**Town & Country Planning Act 1990 (as amended)
Town & country Planning (Development Management Procedure) (England) Order 2015
Application for Planning Permission for Works or Extension to a Dwelling**

Development Pitch roof porch extension
Location 41 Christchurch Crescent Aldwick

Block Plan

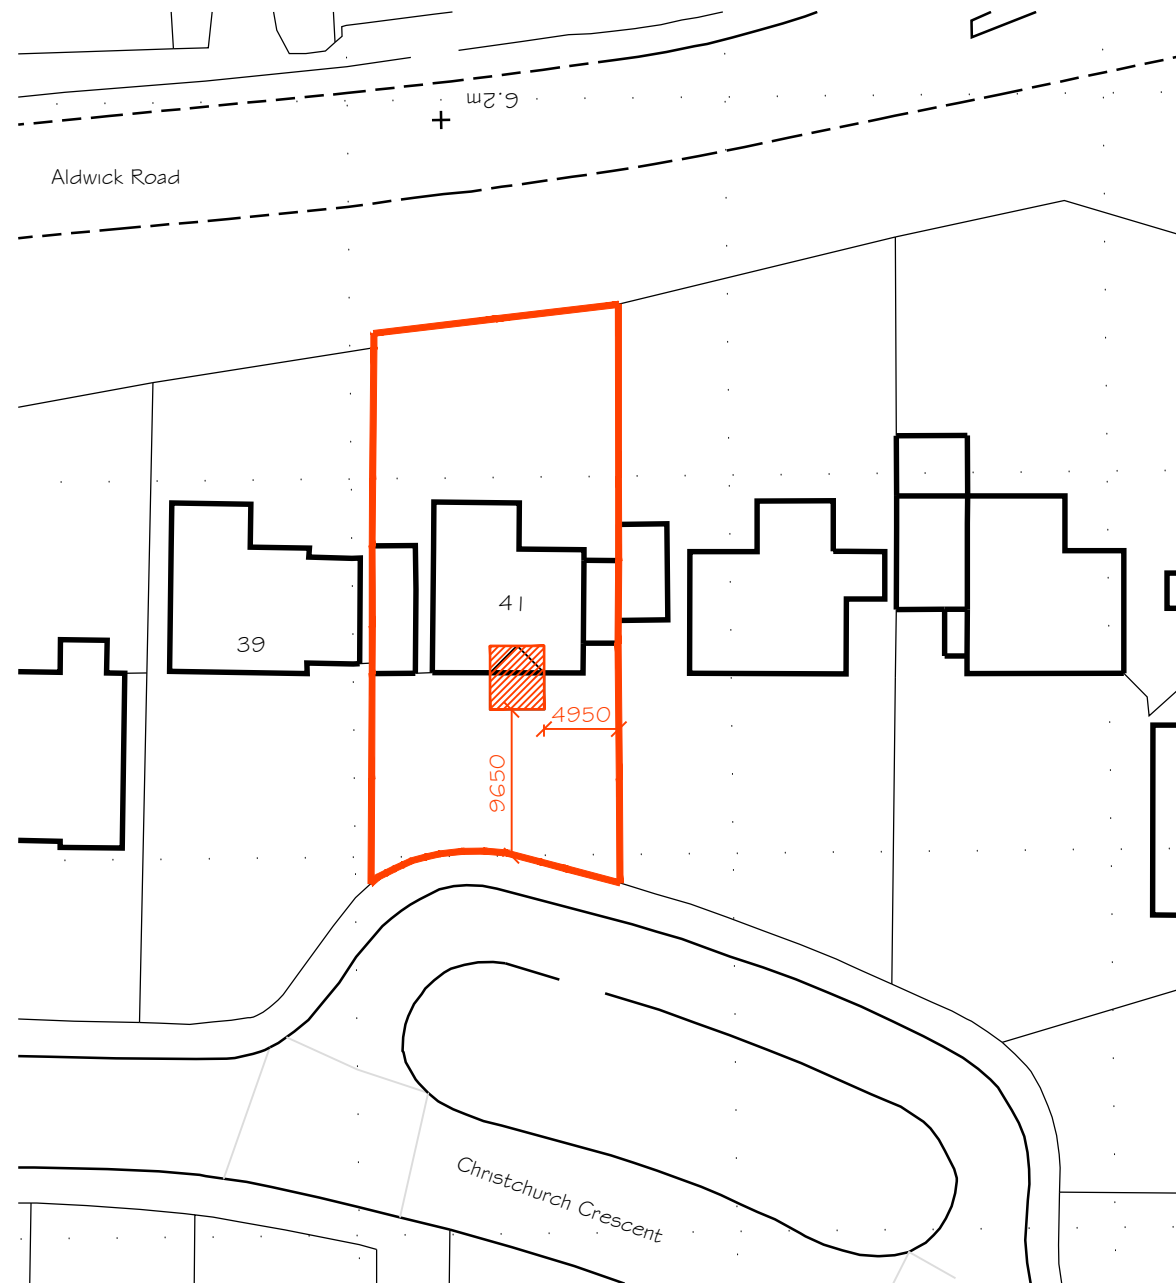
Block Plan Amend

Please submit 1 electronic or 3 paper copies of a block/site plan at a scale of 1:500 or 1:200. Further details of what must be included on the plan can be found in the National Validation Requirements. Please provide measurements from the proposal to the site boundaries.
